Application for a non-material amendment following a grant of planning permission.

Resubmission of planning application relating to design amendments to planning permission 3/2017/0674 in connection with the construction of four dwellings including associated drives, gardens and external landscaping works.

Reference number:	<input type="text" value="3/2018/0344"/>
Date of decision	<input type="text" value="24/05/2018"/>

update to window fenestration to plots 1, 2, 3 and 4.

5513 - P01C

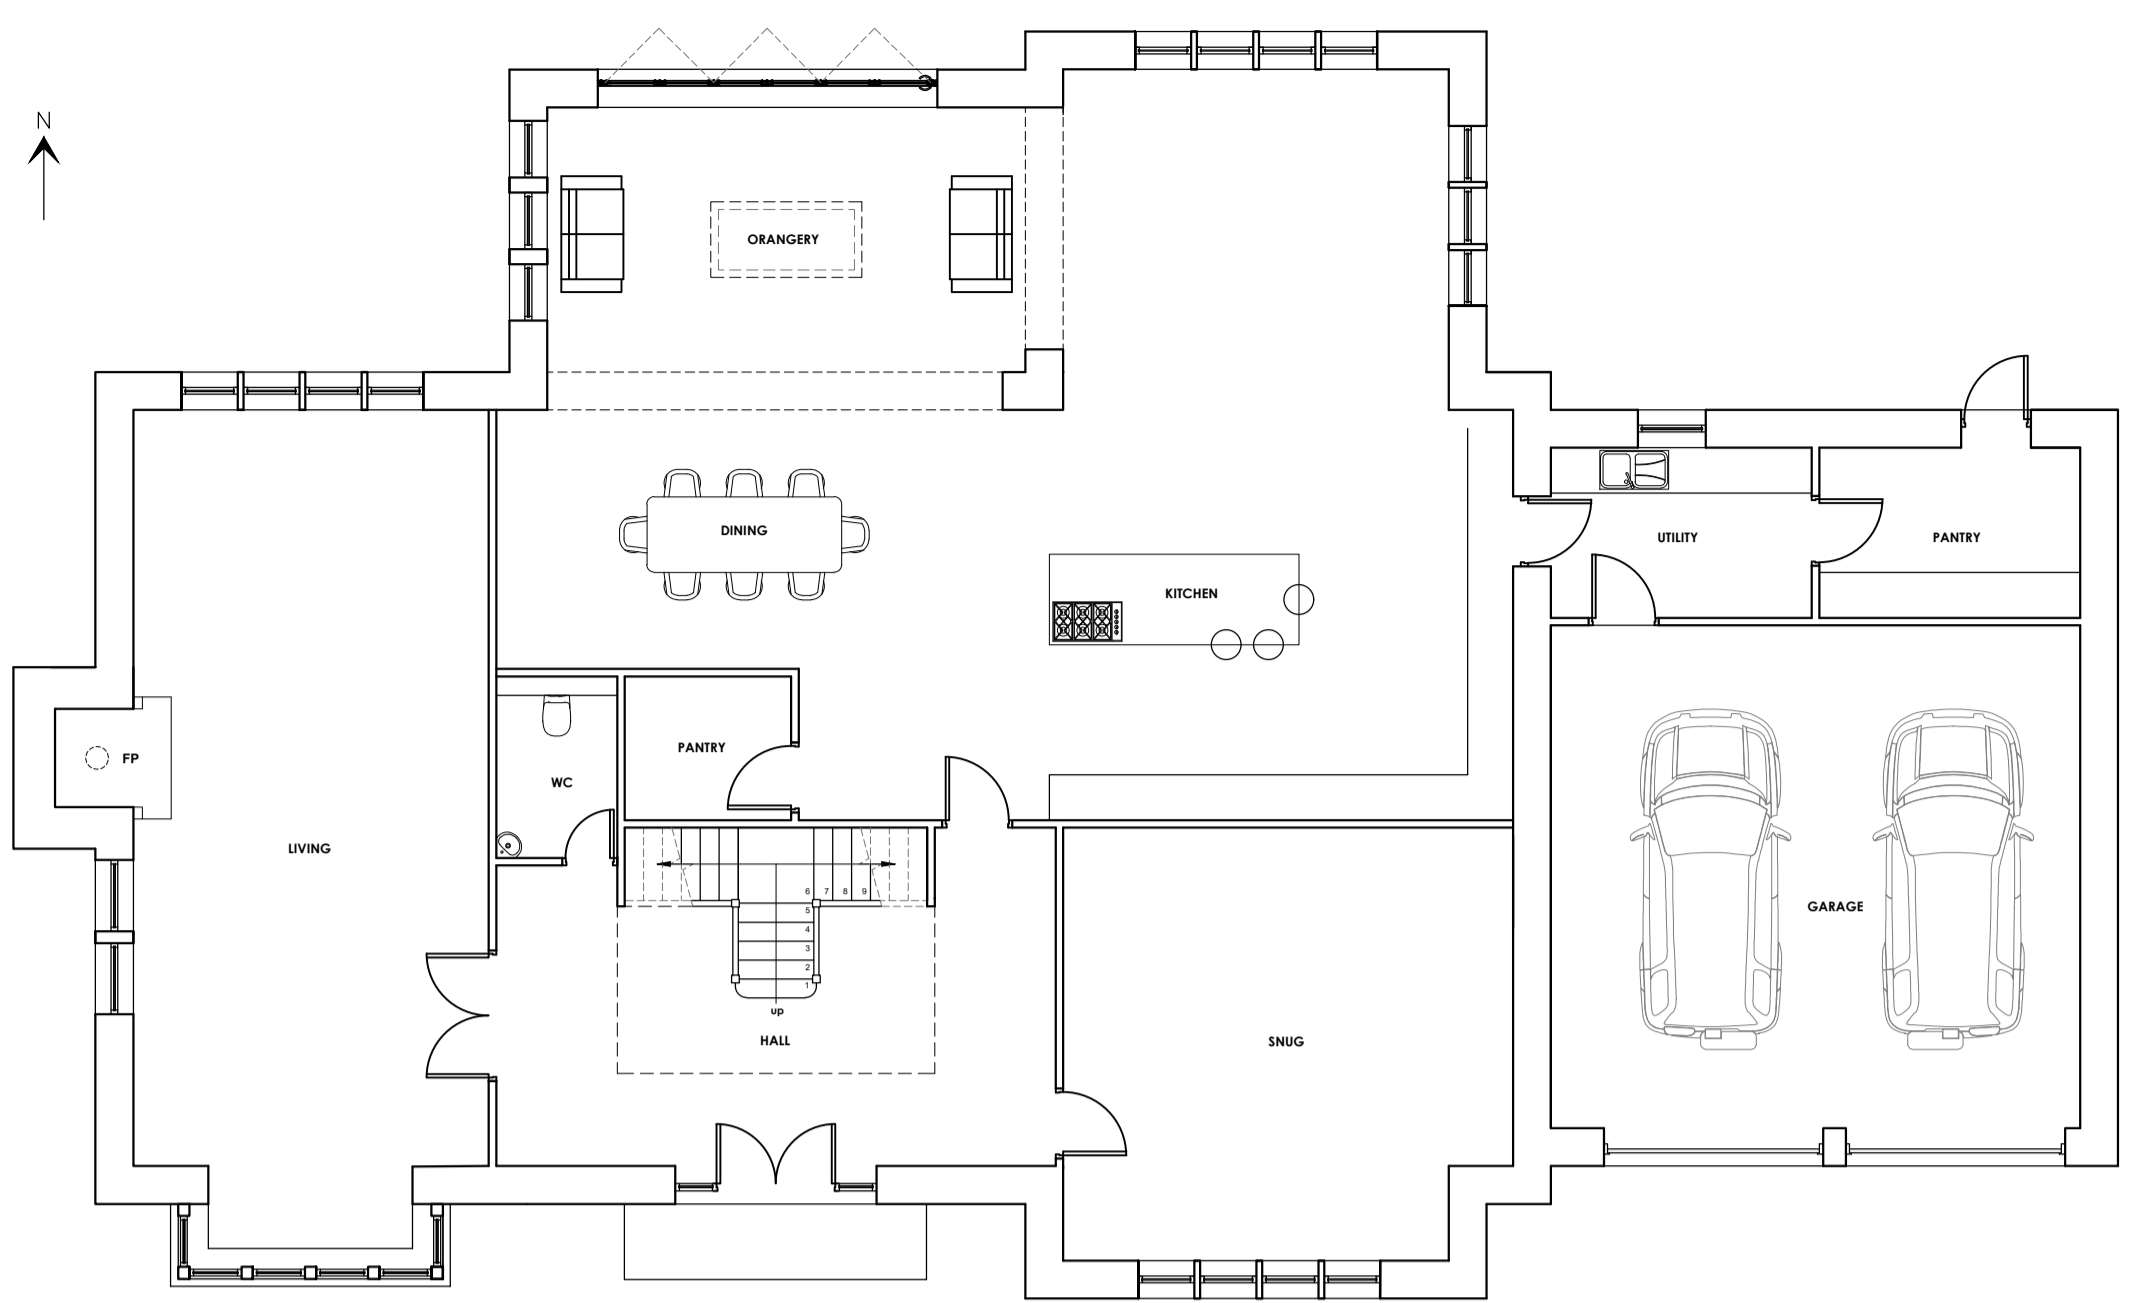
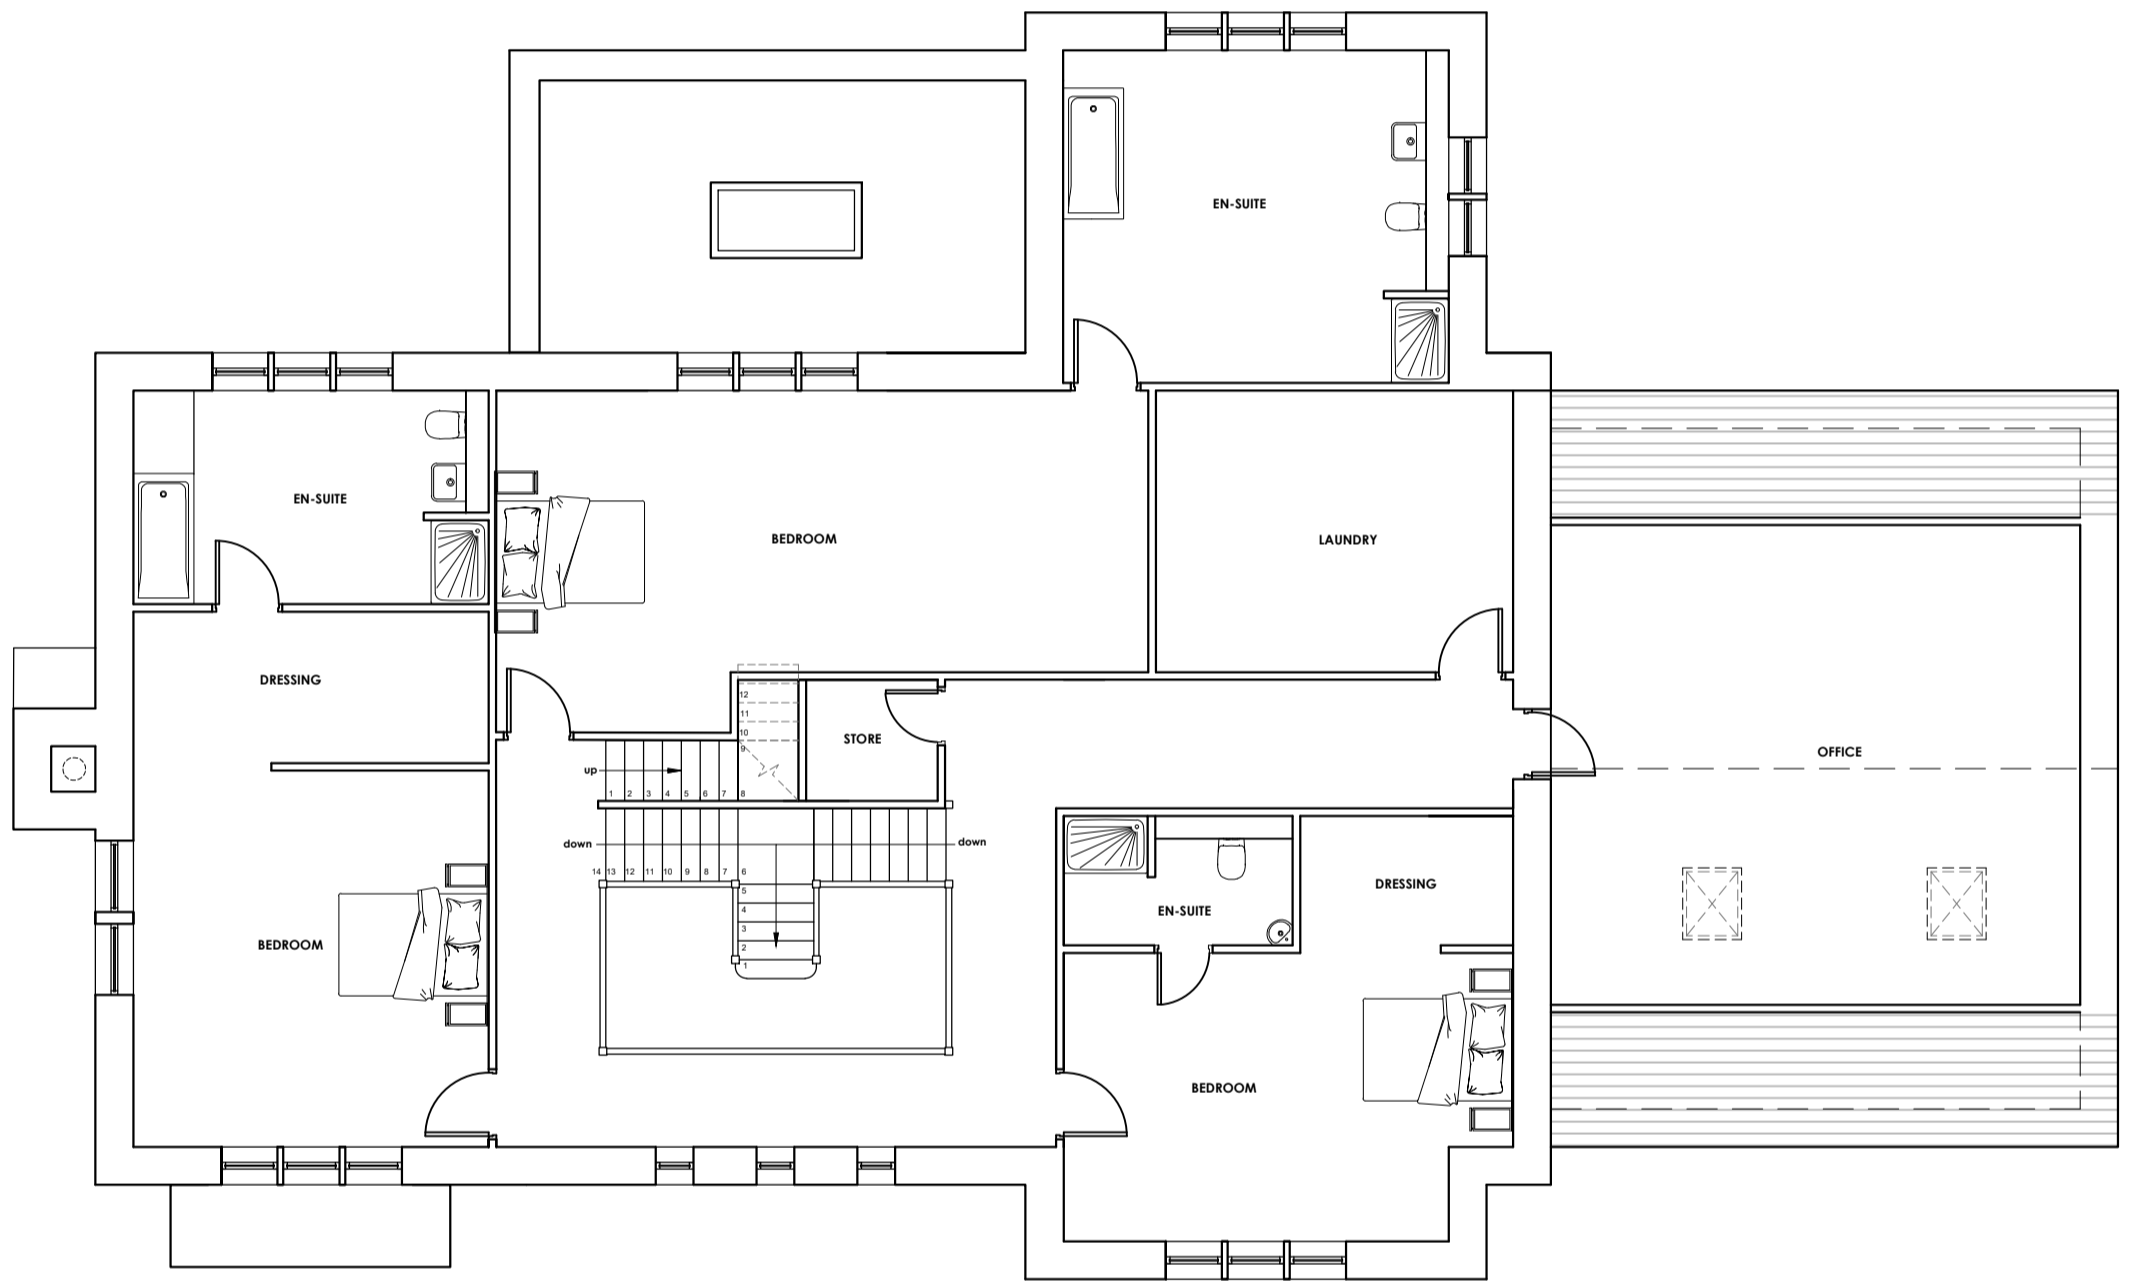
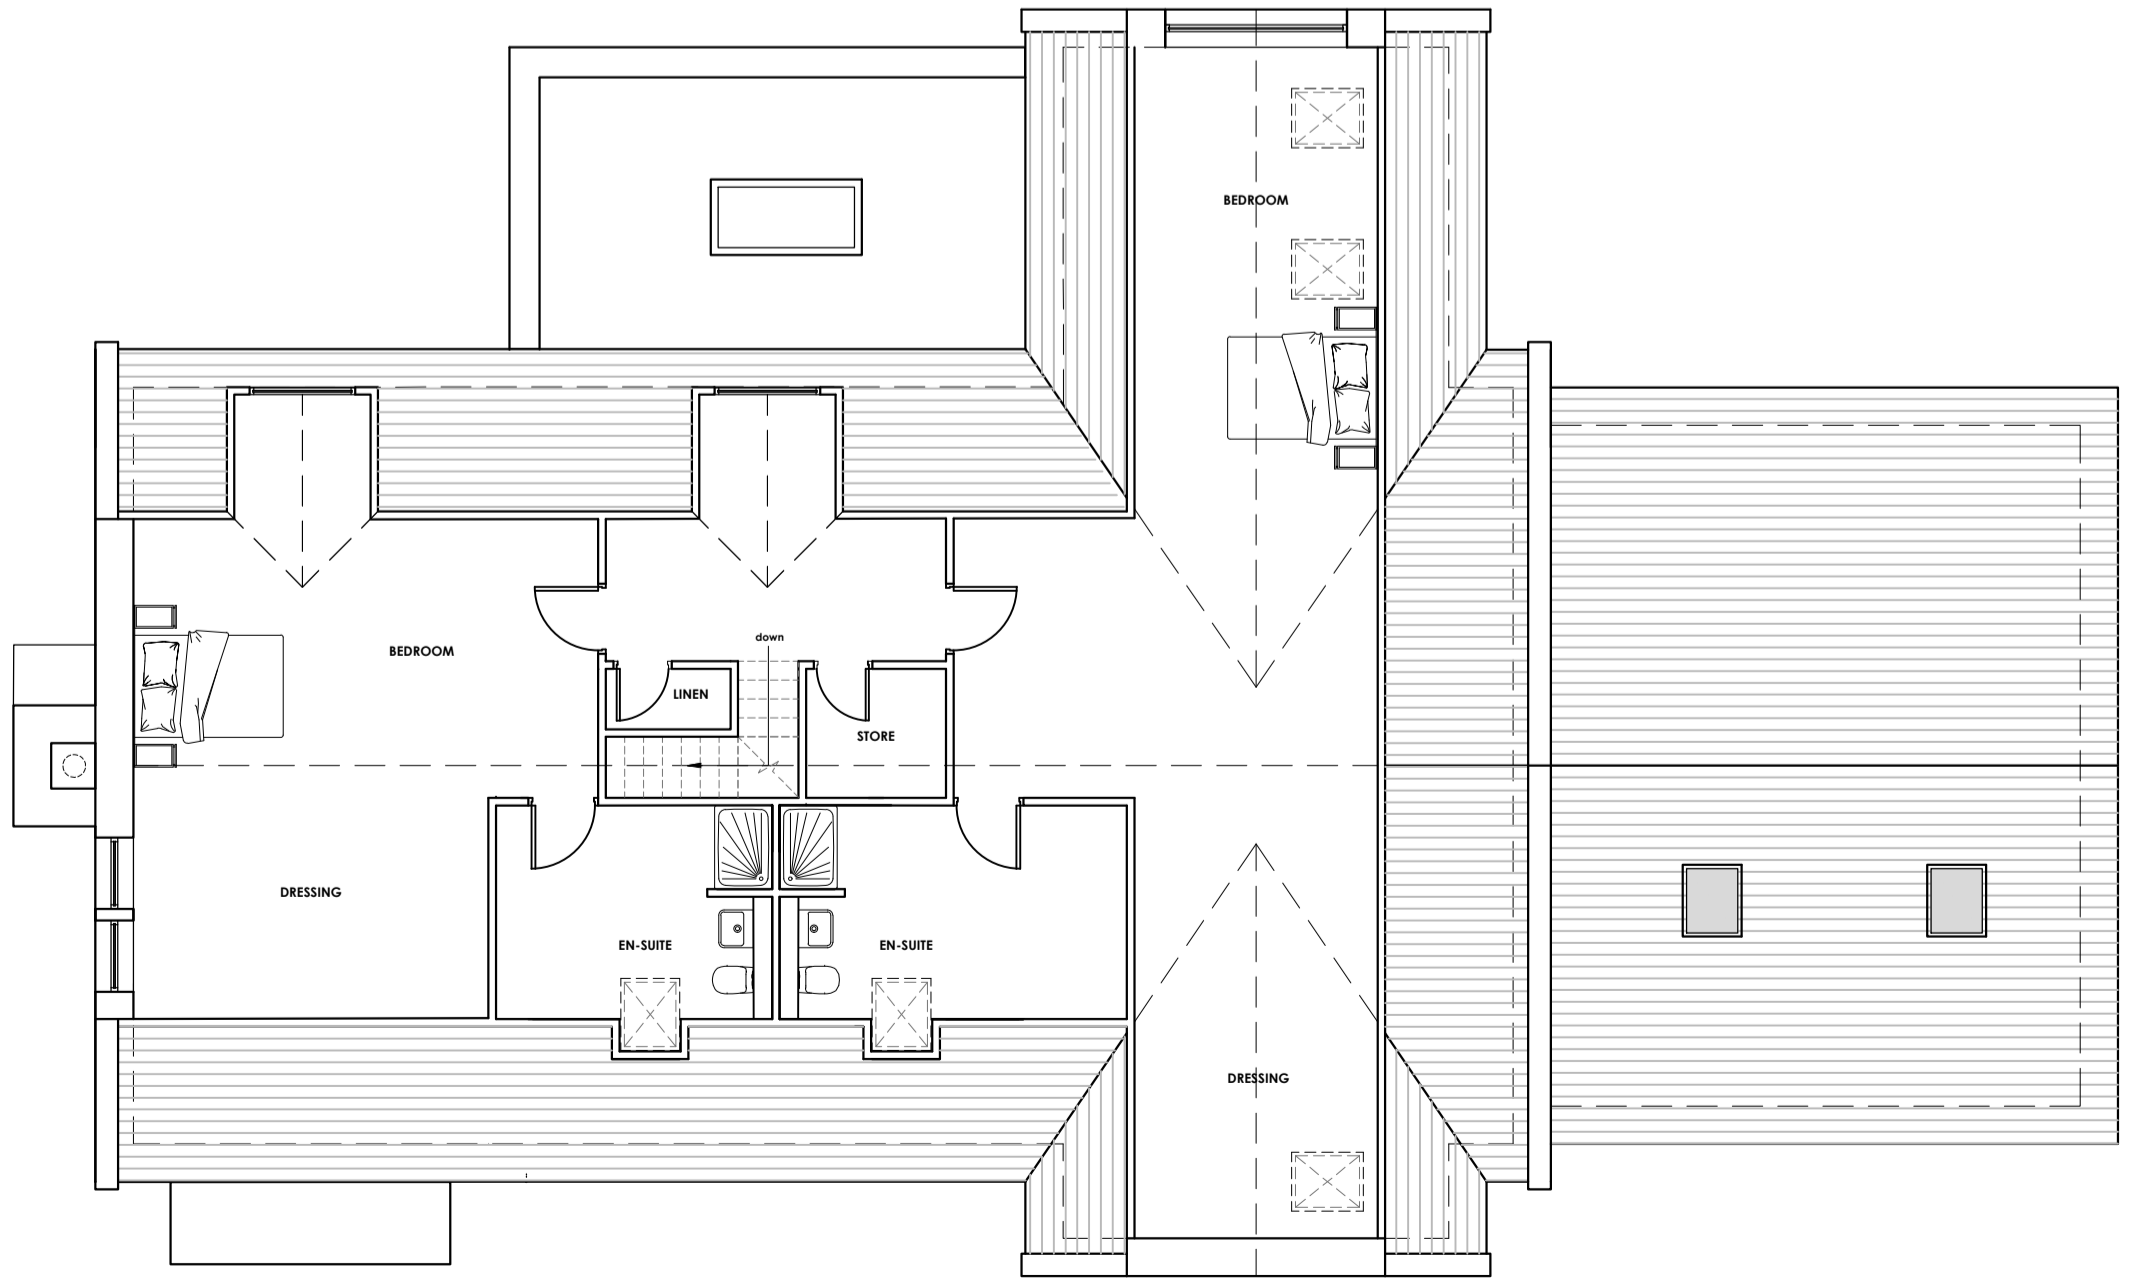
5513-P01B
5513-P02C
5513-P03C
5513-P04C

5513-P01C
5513-P02D
5513-P03D
5513-P04D
